Application for a Non-Material Amendment Following a Grant of Planning Permission

Land to the West Side of Albert Rd

21/01116

Non-material minor amendment of 21/01116 to allow for alteration of external treatment of approved plots 117-118 from brick to white weatherboard

House Type K - Weatherboard and Slate 18564-0375 Rev P-00

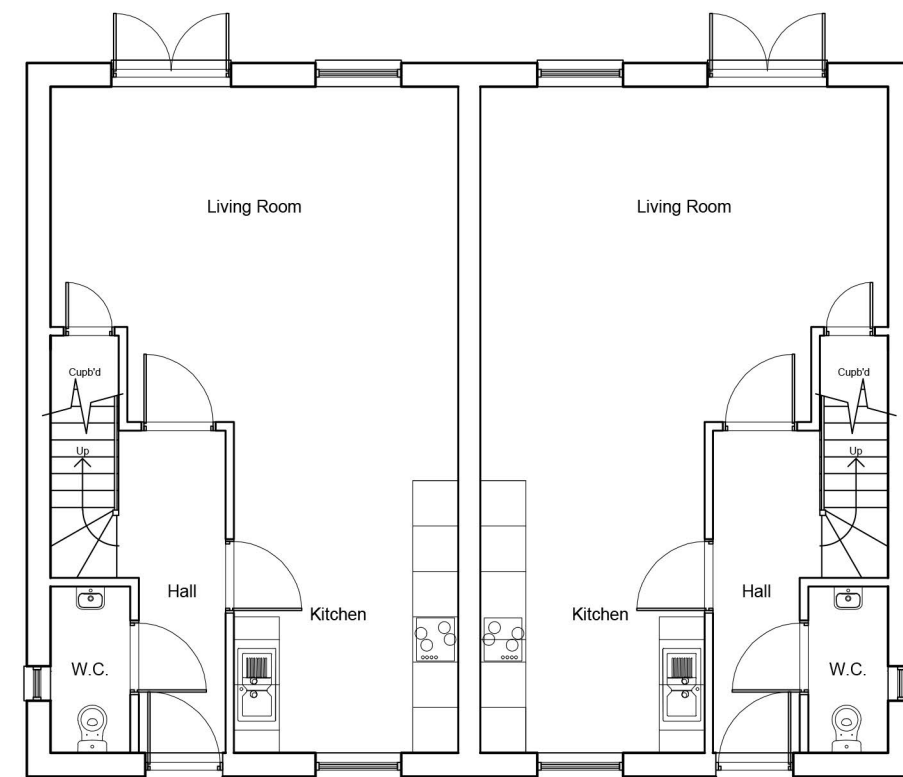
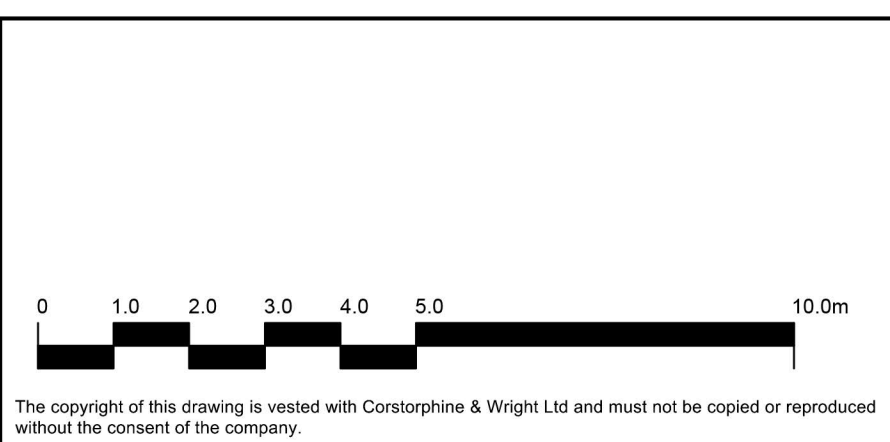
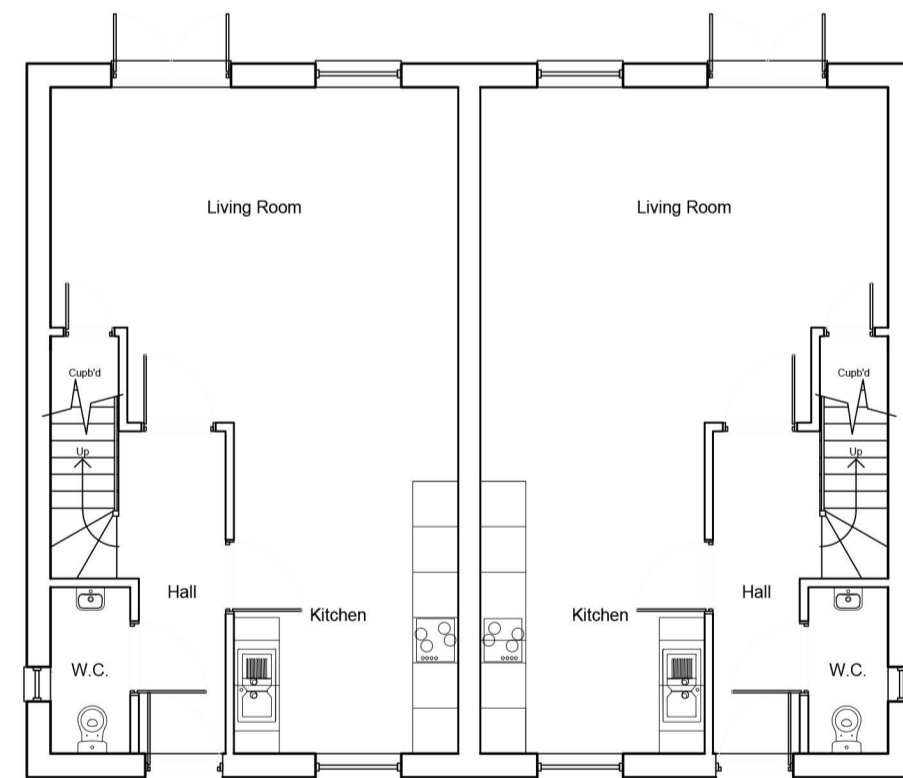
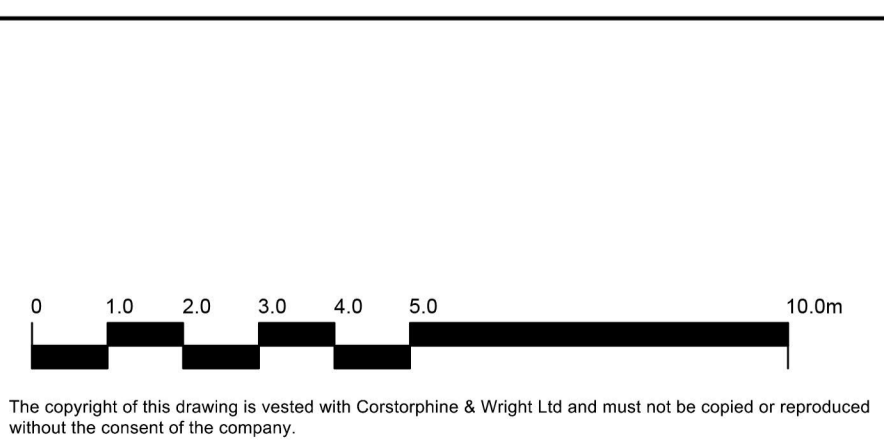
To provide greater streetscene variation

House Type K - Brick and Slate 18564-0350 Rev P-00
